RE: DRB – Project #1009290 – Southwest Mesa/Snow Vista Substation

In response to EPC Conditions of Approval at the July 12, 2012 hearing, PNM's responses are below.

**Project# 1009290 \***  
12EPC-40030 Site Development Plan for  
Building Permit

DATE: August 31, 2012  
TO: Jack Cloud, DRB Chair  
FROM: Catalina Lehner, Senior Planner *cel*  
RE: Project #1009290, PNM SW/Snow Vista Substation  
Site Development Plan for Building Permit

DEVELOPMENT SITE PLAN  
FOR BUILDING PERMIT  
SNOW VISTA (AKA SOUTH WEST MESA)

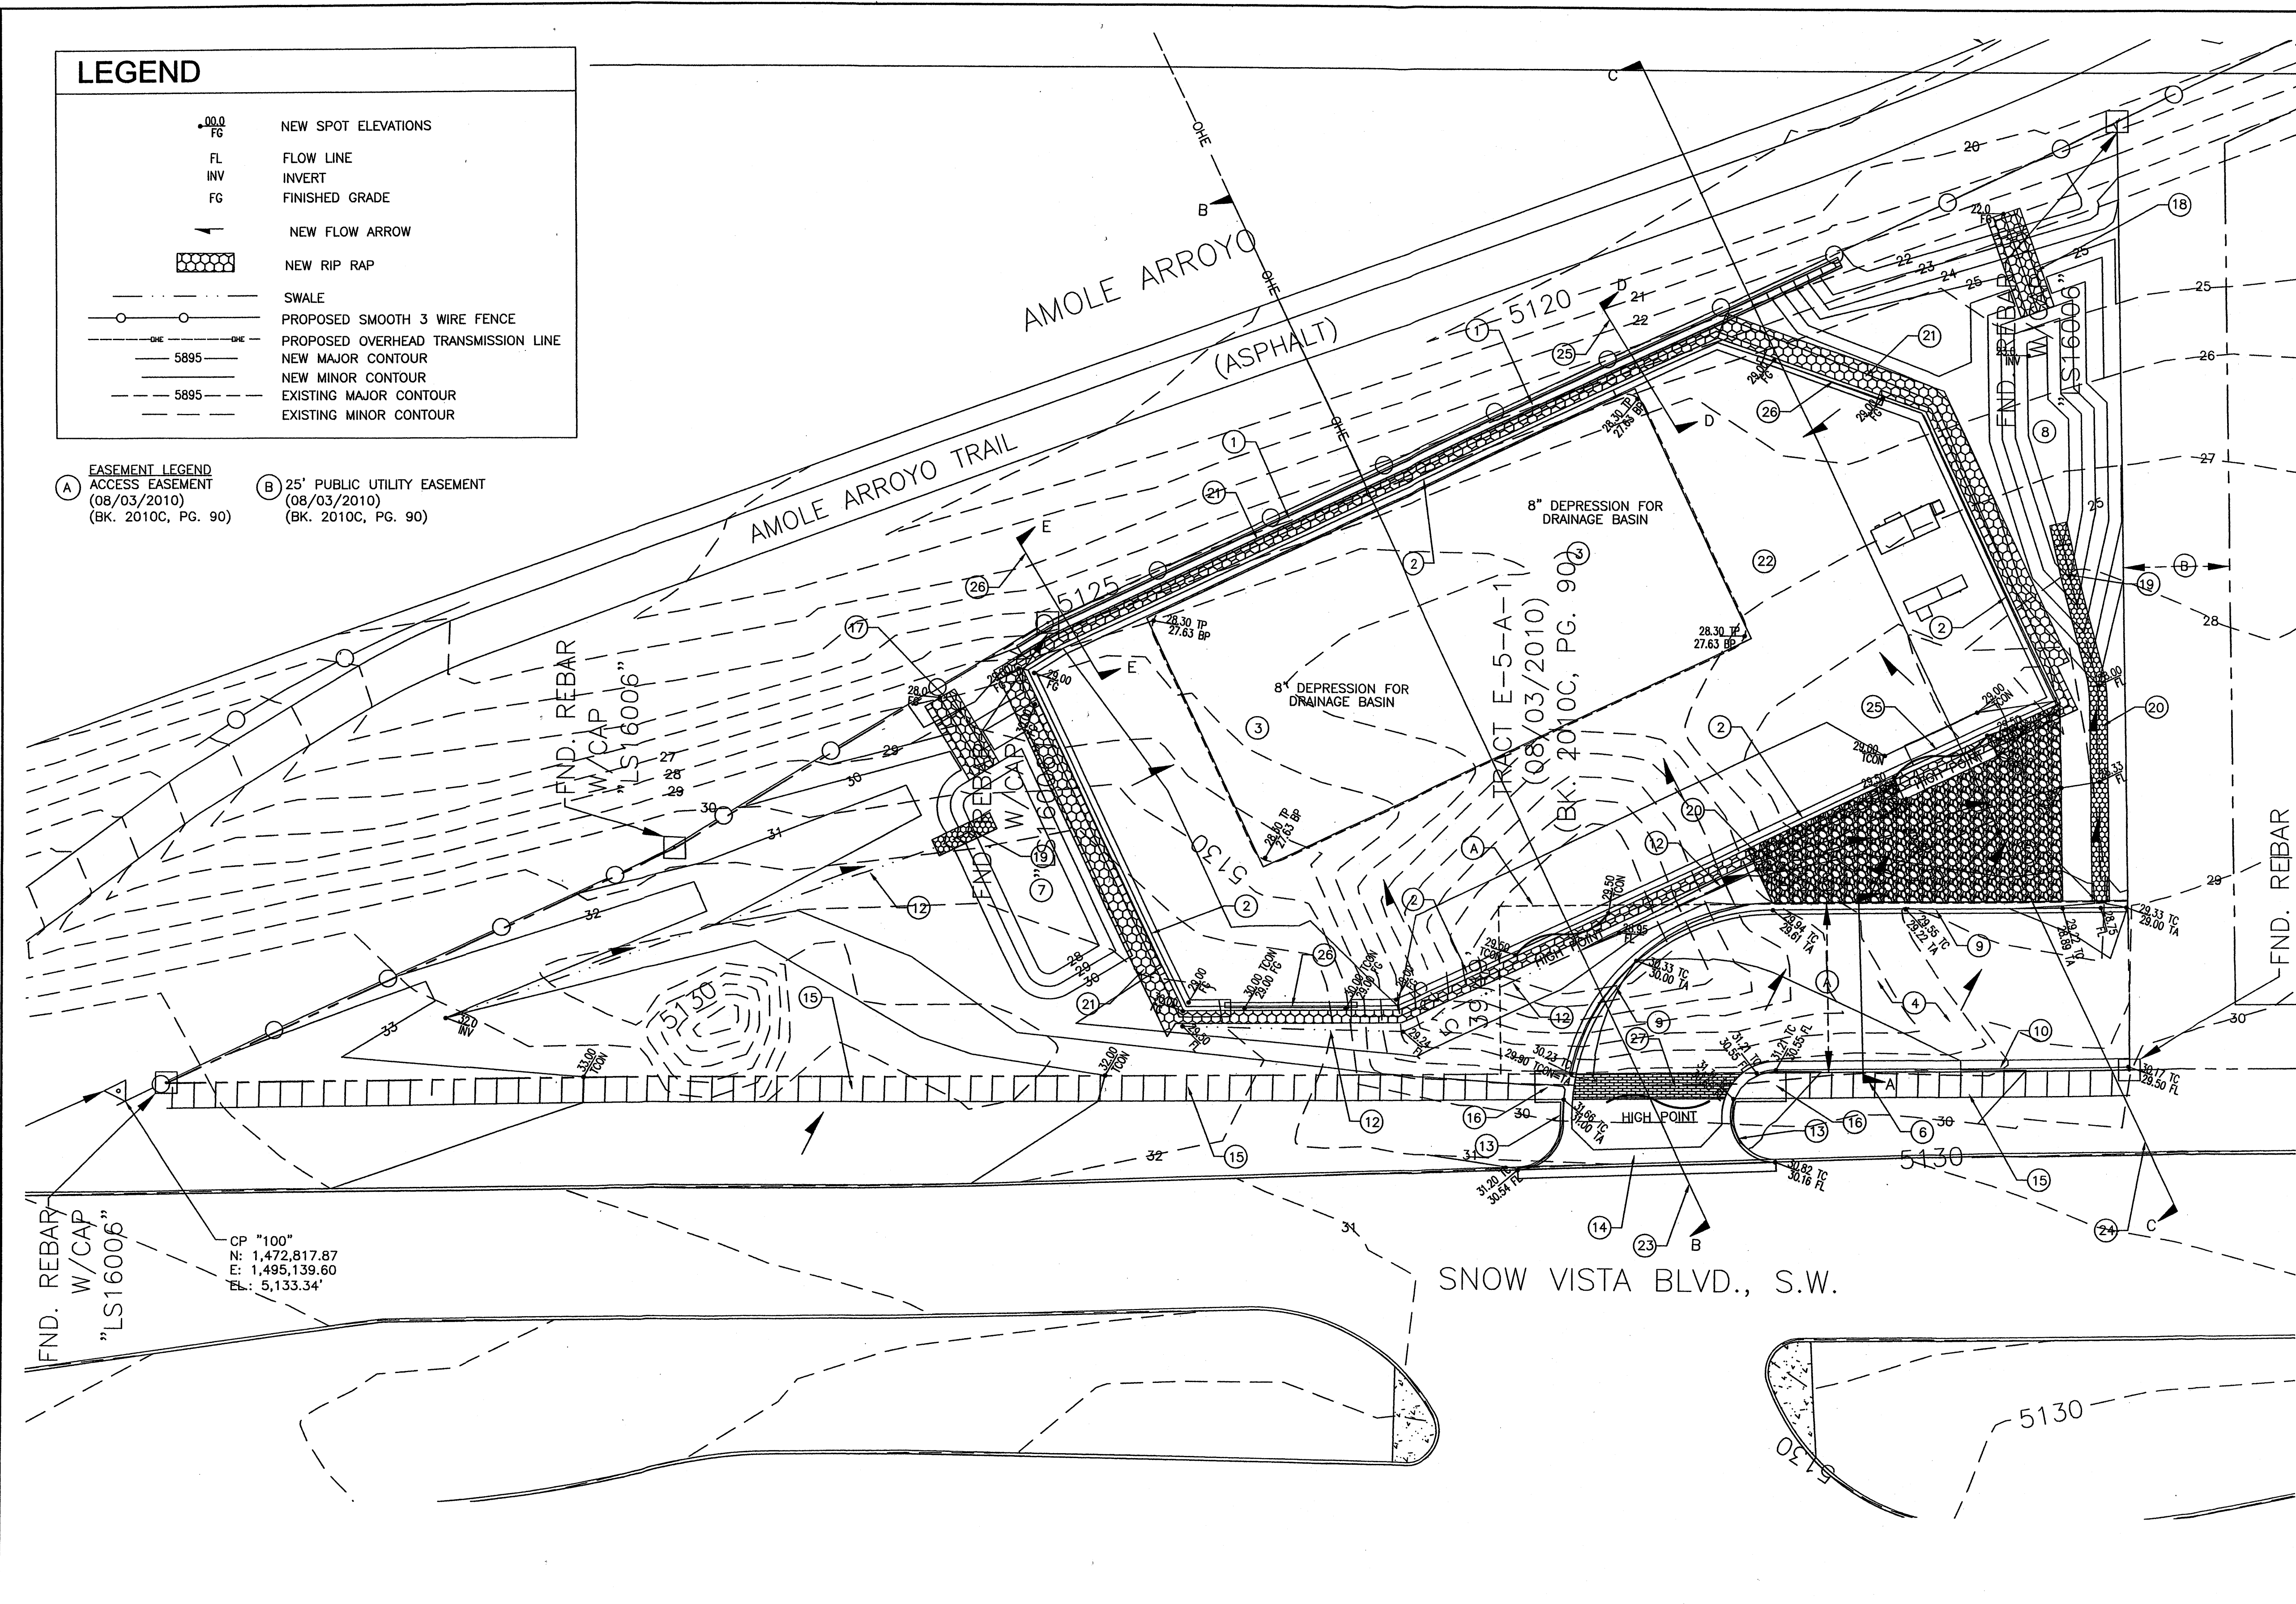
- D. *A note shall be added to the site development plan to explain the use of steel wire.*

Verify the size of the subject site and state it (Sheet 1).

PNM Response: In the Legend on Sheet 1 added the following: Proposed smooth 3-wire fence replaces the AMAFCA existing barbed wire property line fence.

PNM Response: The size of the subject site has been revised on Sheet 1 to reflect the correct acreage of 1.1669 acres.

PNM Response: Sheet 1, Site Plan, has been labeled: Site Development Plan for Building Permit.

SNOW VISTA SUBSTATION RETAINING WALL
SHEET 3 OF 7

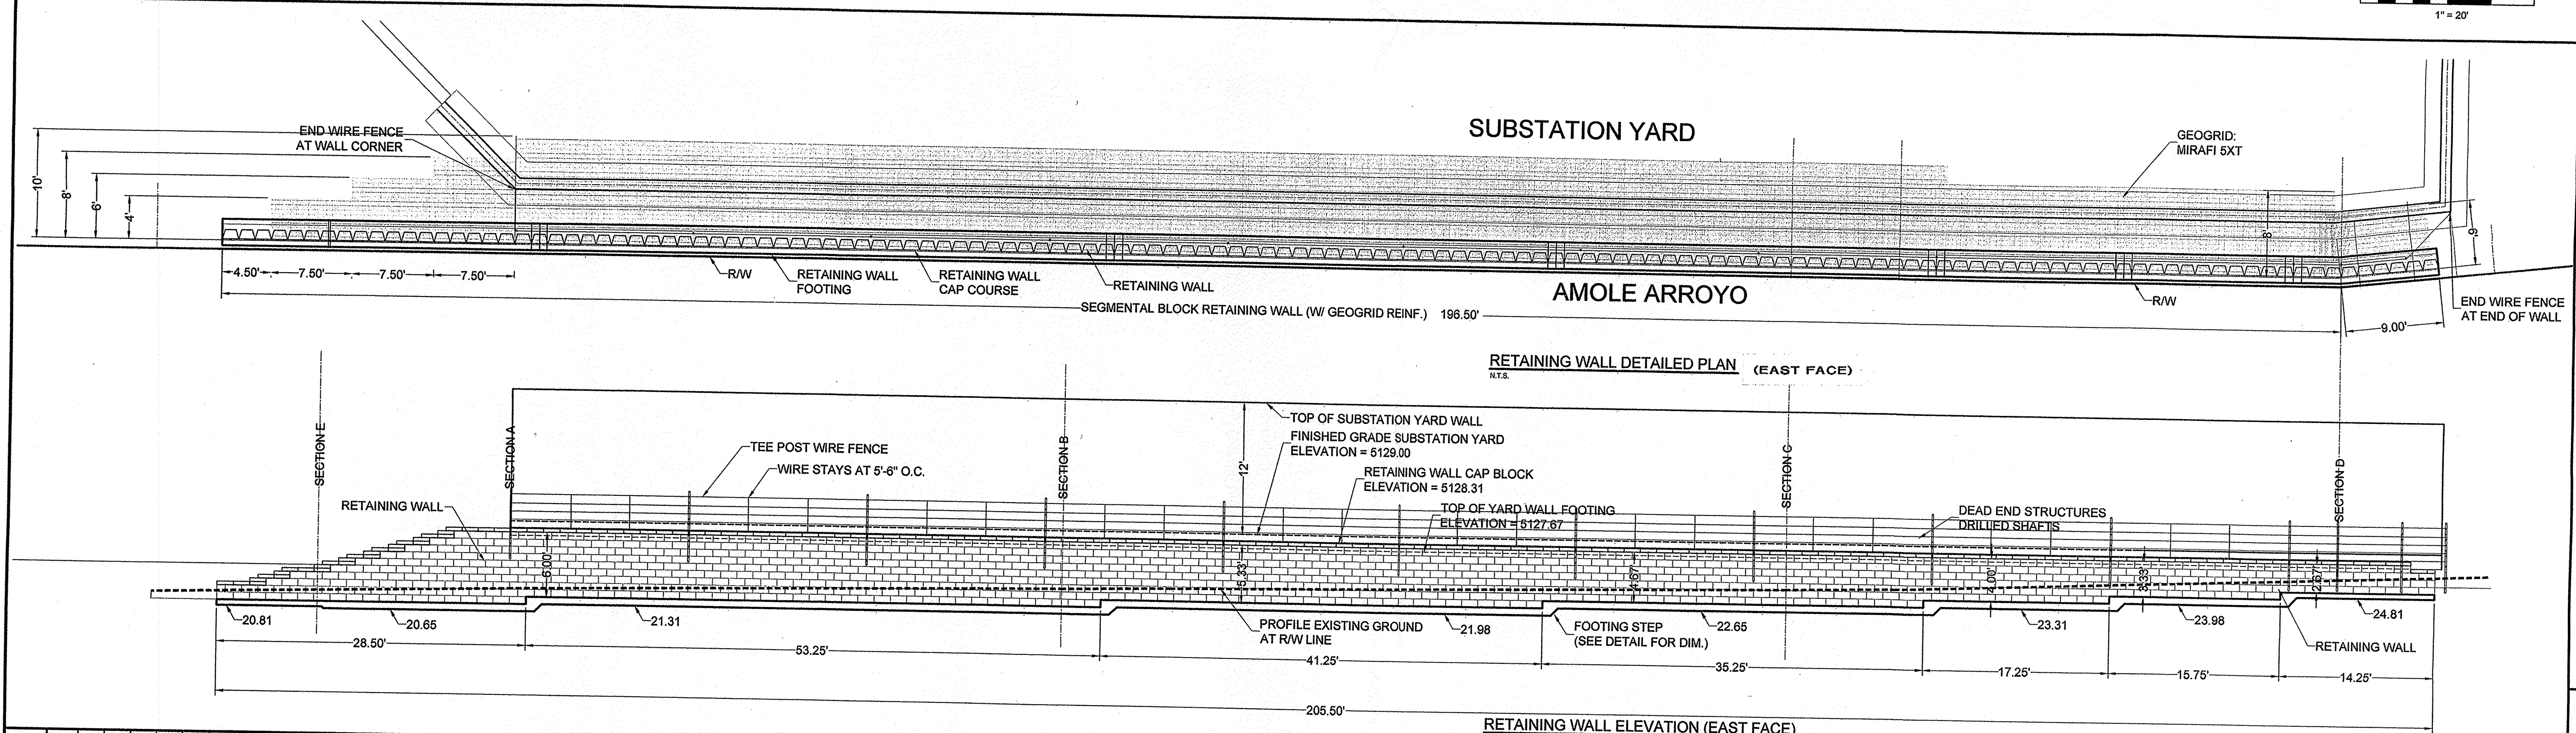
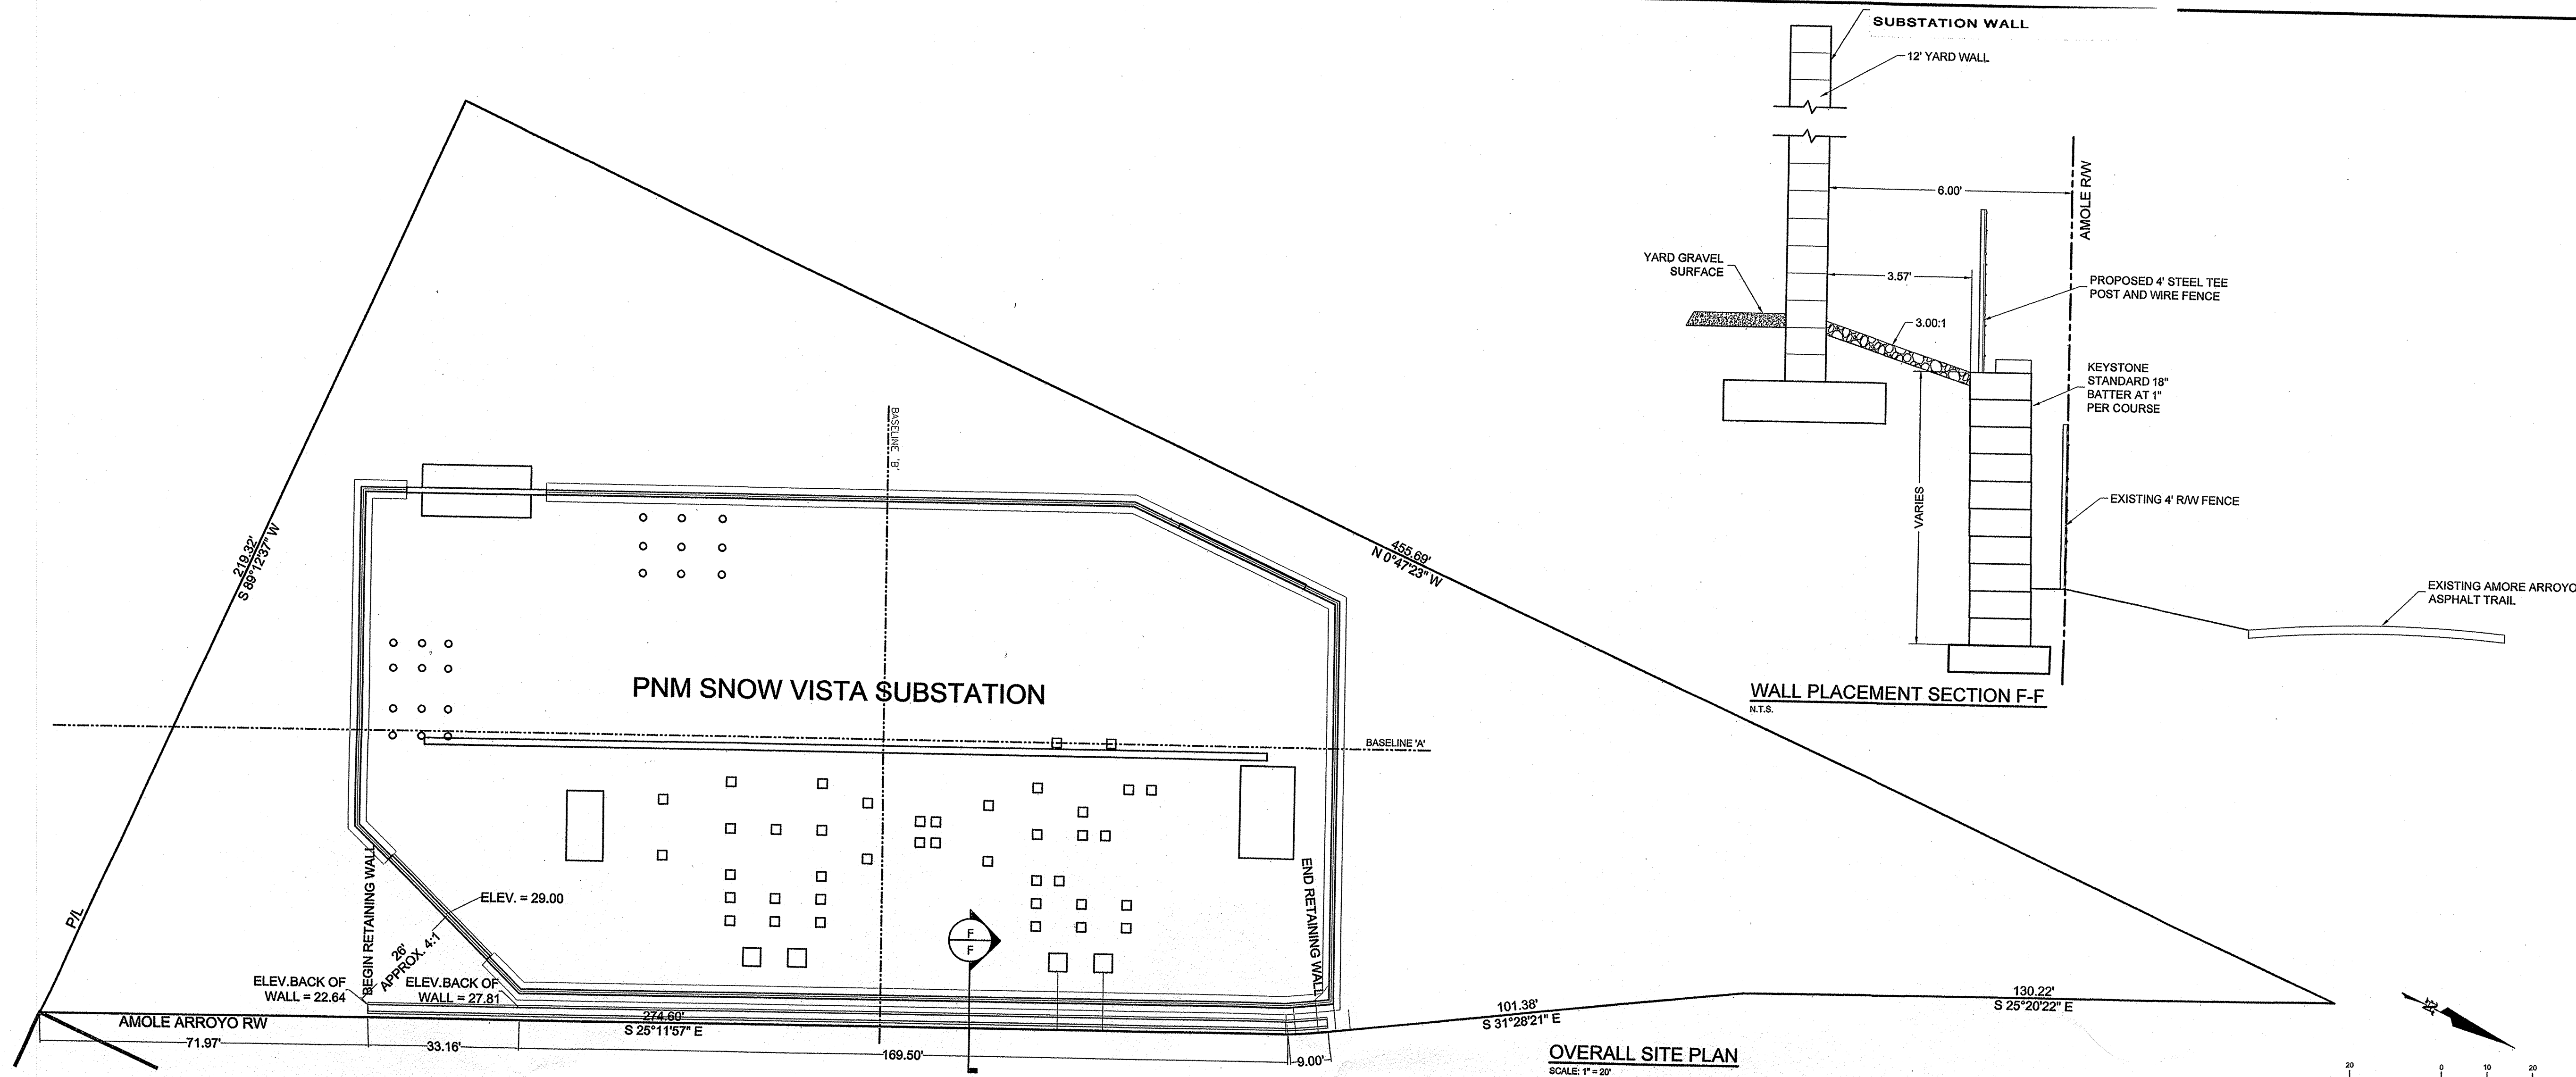
- C. *The retaining wall block color shall be specified and shall match the Pecos Gold color of the yard wall.*

A. *Show the wire fencing on the eastern elevation.*

PNM Response: On Sheet 3, the following note has been added: "Retaining Wall Block, color is Pecos Gold #250 (Utility Block Company, Inc.)."

PNM Response: The wire fencing has been added to the Eastern Elevation on Sheet 3.
